From: Sue Howell
Sent: 12 June 2019 14:07
To: Planning.Responses
Cc: Simon Davis
Subject: RE: Planning Consultation on: BR/49/19/OUT

Comment from Greenspace,

BR/49/19/OUT

Description of Works: Outline application with all matters reserved for 22 No. new dwellings consisting of 2 No. 1 bed dwellings, 18 No. 2 bed dwellings & 2 No. 3 bed dwellings.

Roof / Site Plan (Proposed) 1:200

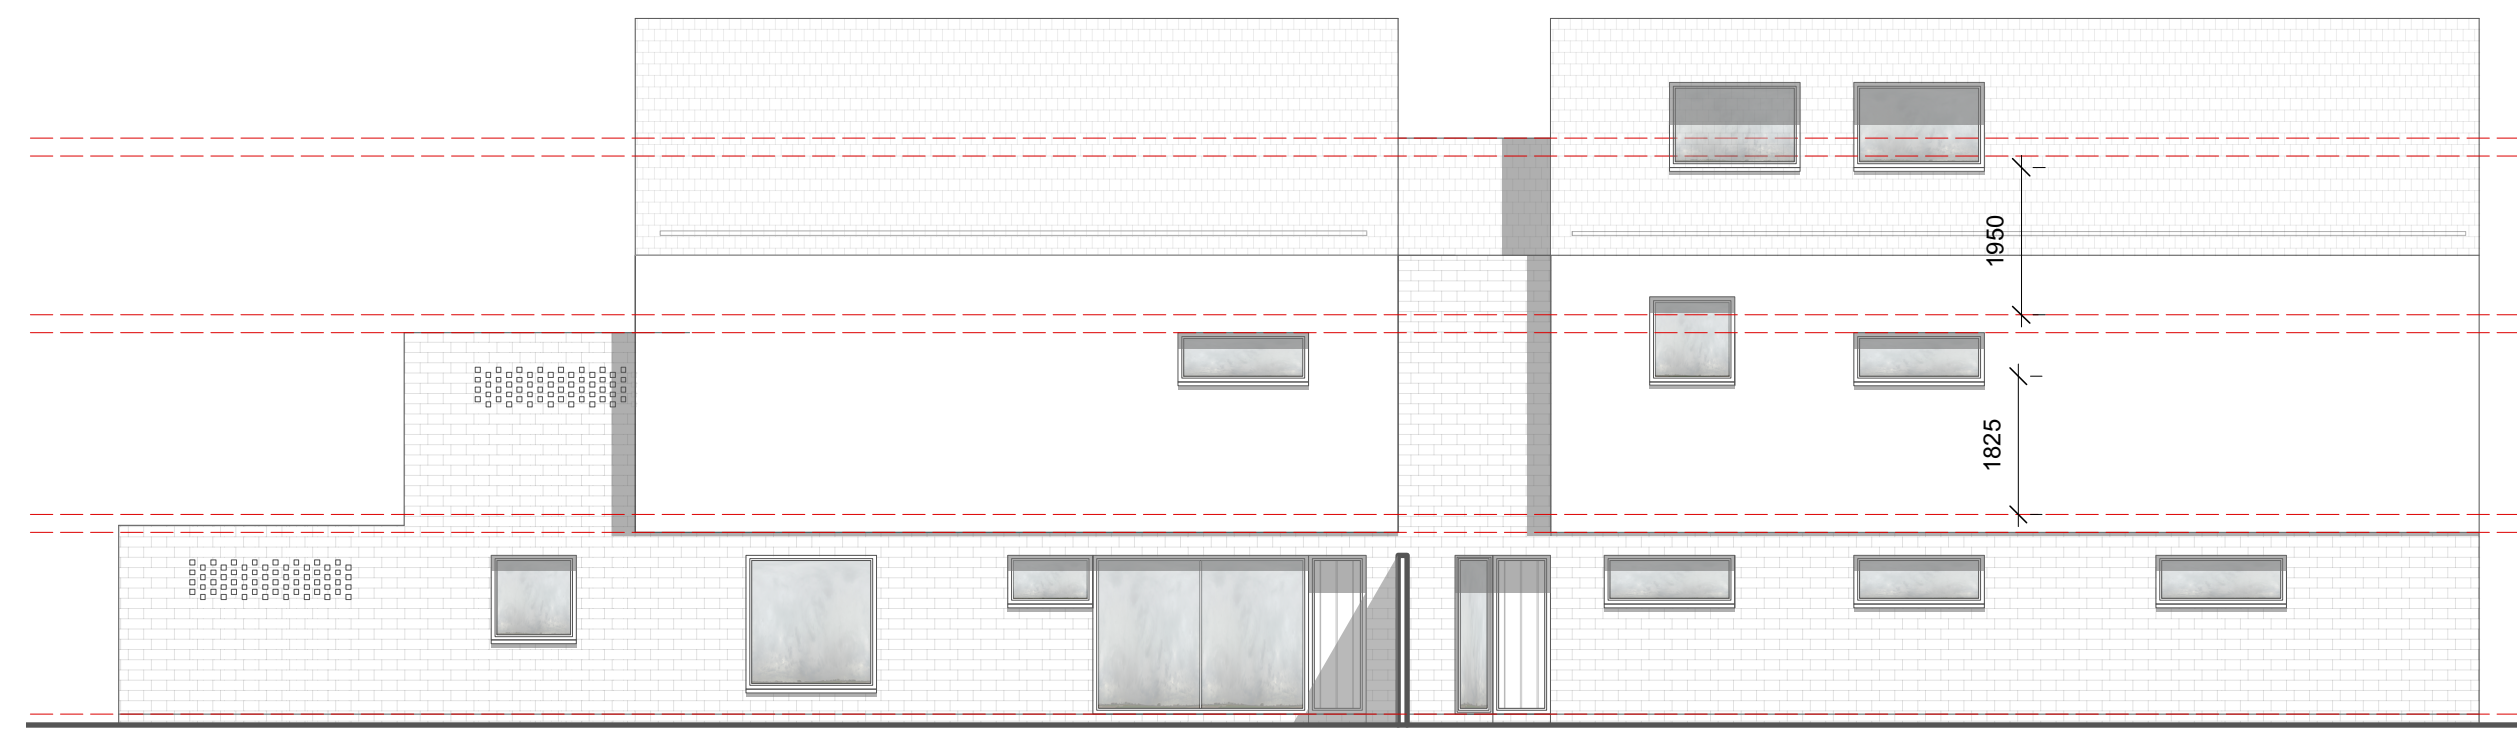
As this is a proposal for a development of residential flats there would be no specific requirement for POS or play area contribution. However greening to soften the development would be required on a development of any kind also for the surrounds to be appropriate for use and location. It would appear that the proposals will dominate this plot and the neighbouring properties where there would appear to be no scope for suitable landscaping that could in any way enhance the proposals or make them fit in the location.

Forming part of any application and at least conditioned would be the requirement of the submission of a full landscape scheme which should be submitted for approval, detailing species choice, position, densities and size at time of planting. This should be plotted in plan and list form and in relation to the trees and vegetation to be retained in the locale, so that a clear picture of the proposals can be seen. These details are required to assure the proposals are appropriate to its setting and to ensure that appropriate screening is provided, maintaining and uncompromising the setting and ensuring that the proposals fit within the area of neighbouring and adjacent properties.

The existing trees in particular along the boundaries and to the north/east of the proposals provide potential valuable screening and appear to be compromised by these proposals. Root protection Areas (RPA) should extend into the development site and to those in neighbouring land. Before construction, a tree protection scheme must be in place for any adjacent trees whose root protection areas fall within the construction zone from neighbouring land. This should be in accordance with BS 5837:2012 'Trees in relation to construction'

I would not be supportive to the proposals as failing on High Quality Landscape design principles and that they compromise the existing trees within this plot with no mitigation indicated.
